MEMORANDUM

SUBJECT: **On-Call Contract #17-067H-1; PO # 8113073**
Bridge Reviews
Task Order #6: Mesa Top Bridge Submittal - Fifth Review

This memorandum provides a list of comments for the 5th Submittal of the Mesa Top Bridge, based on requirements in the County's Engineering Criteria Manual (ECM), 2019 CDOT Standard Specifications for Road and Bridge Construction, Current CDOT Bridge Design Manual and the Current CDOT M&S Standards Plans.

FOREST LAKES FILING NO. 6
 BRIDGE HYDRAULIC INFORMATION
 MESA TOP DRIVE OVER NORTH BEAVER CREEK

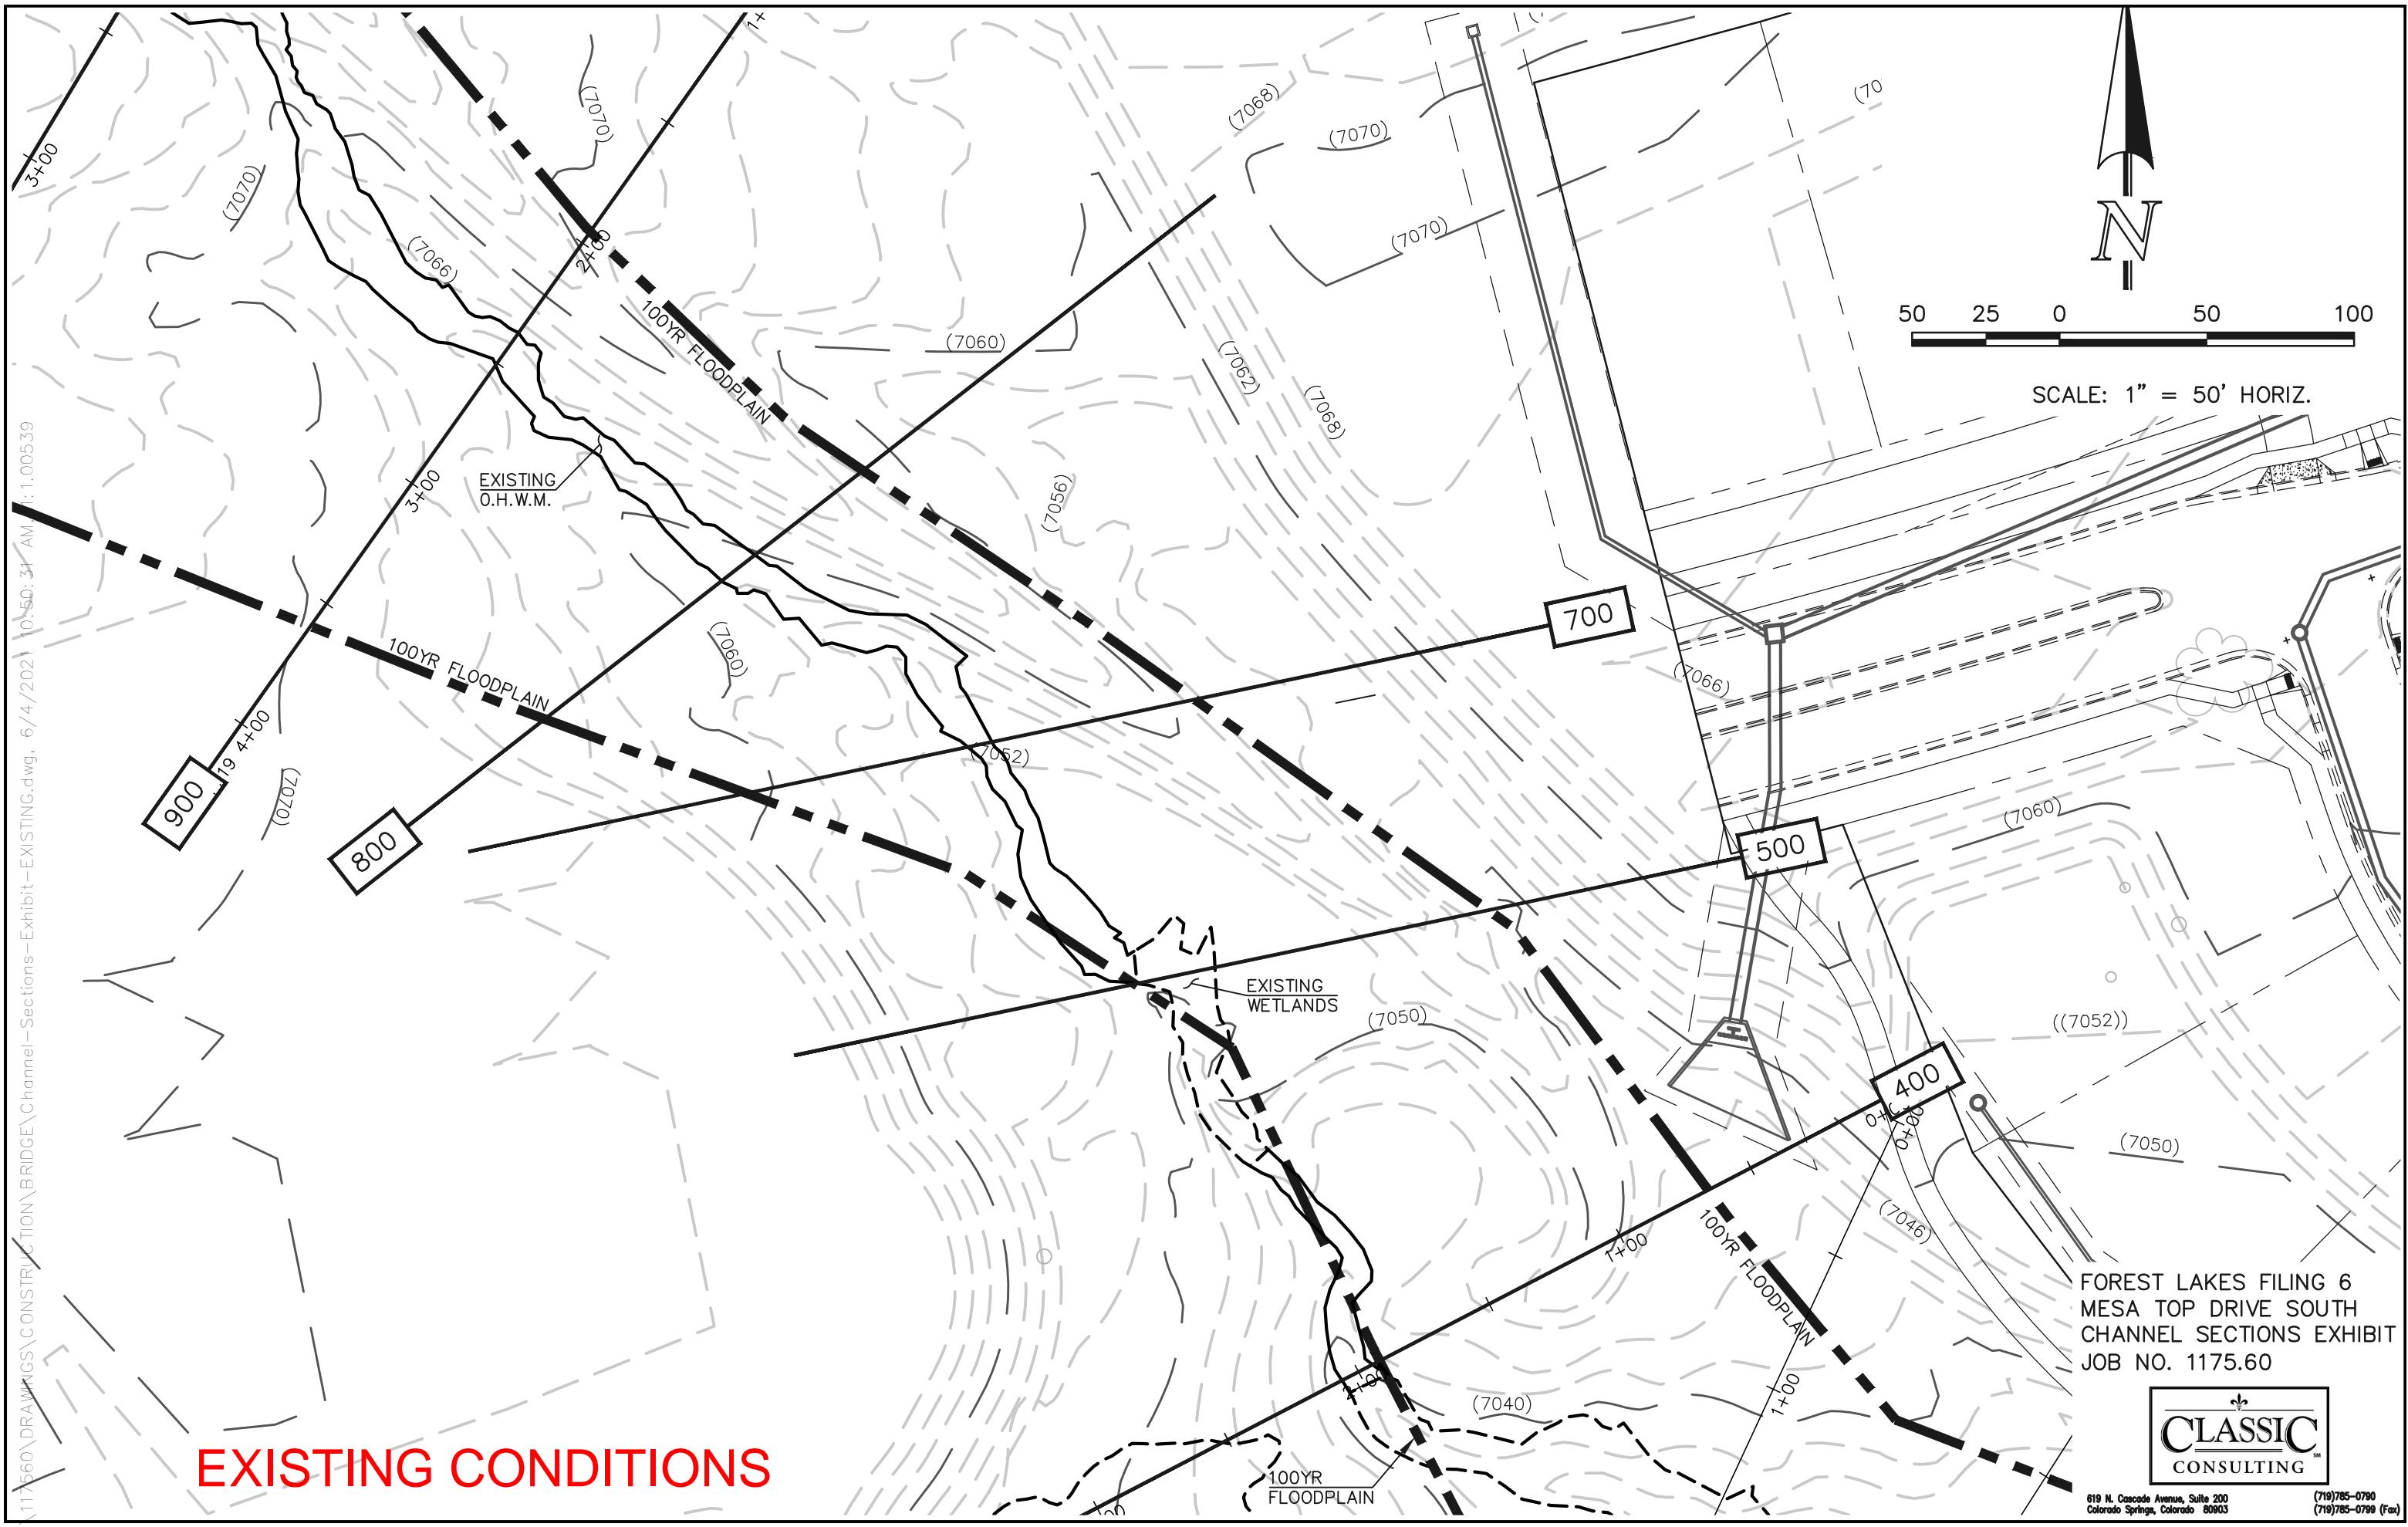
1. It still does not appear that the horizontal limits of the riprap have been shown. If the information is provided elsewhere or it is not a concern, please reply accordingly.
2. Please provide scour limits on the section view or in a note on the bridge hydraulic sheets.
